Application for Planning Permission

Development: Erection of single storey rear extension following the demolition of existing lean to.
Location: 5 Davenport Road Felpham PO22 7JP

Proposed Ground Floor Plan

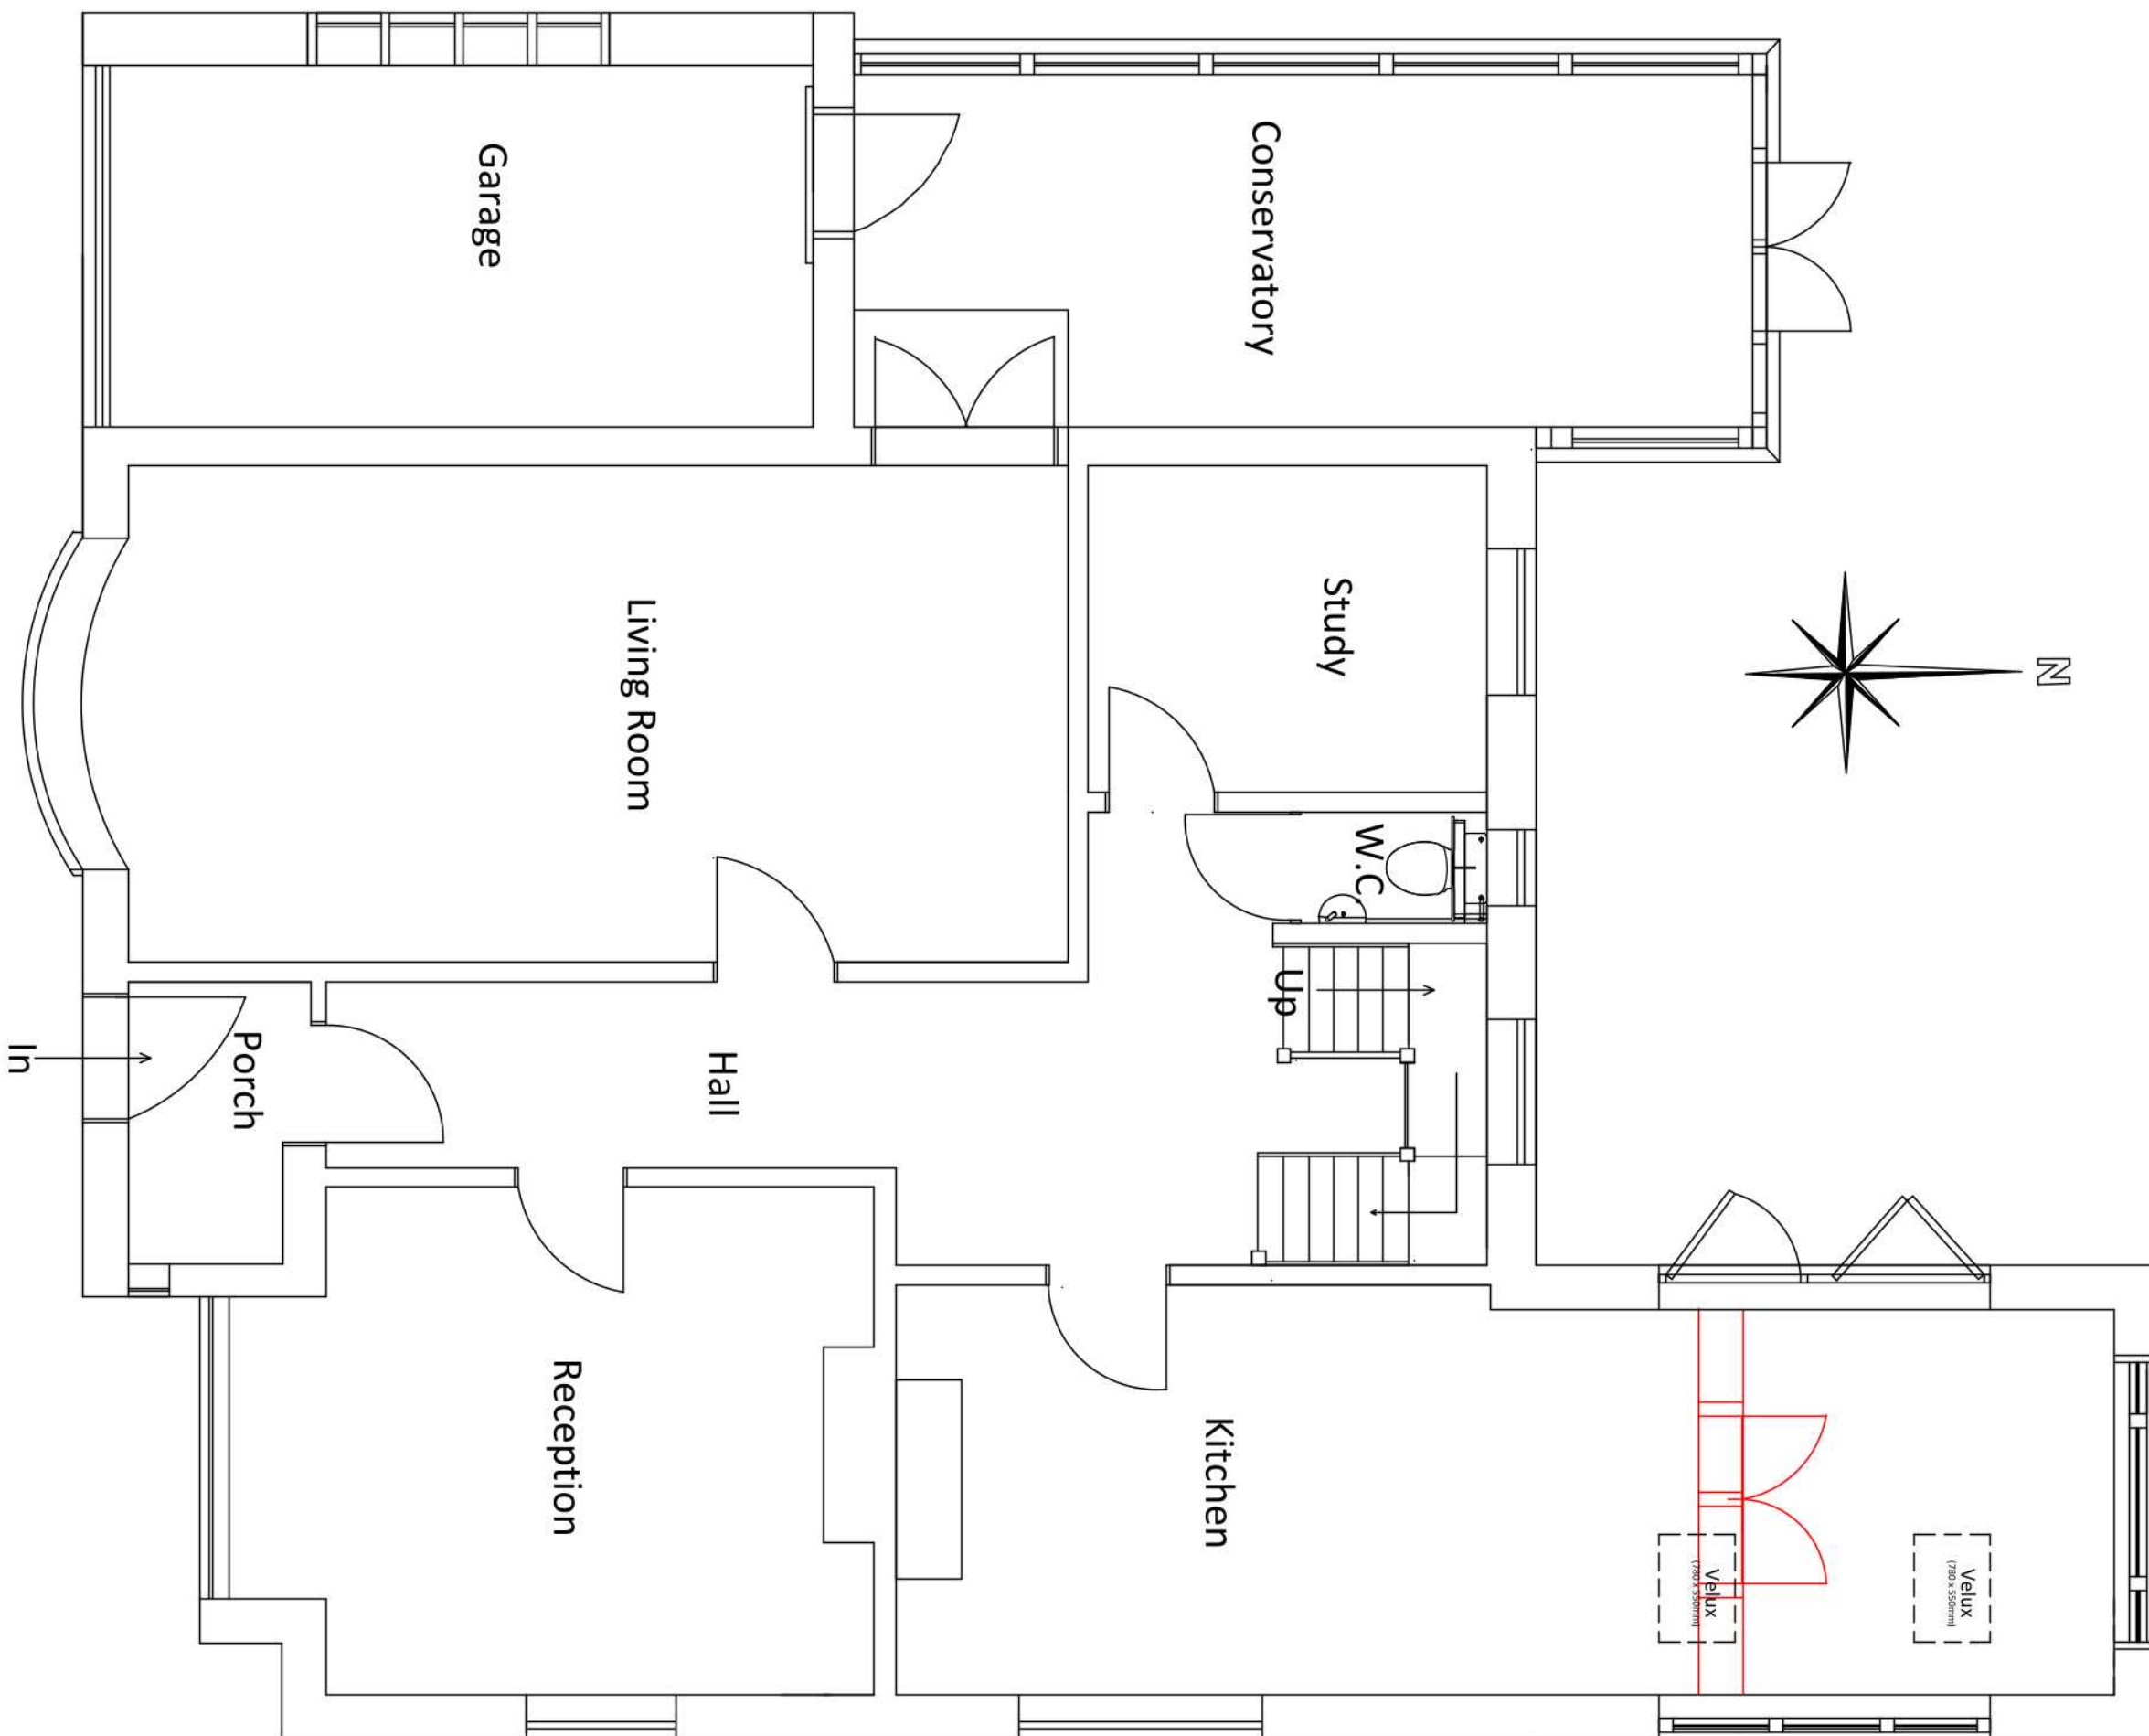
Please submit proposed elevations at a scale of 1:50 or 1:100. Along with this, the proposed floor plans require a stated scale. Further details can be found in the Validation Requirements List.
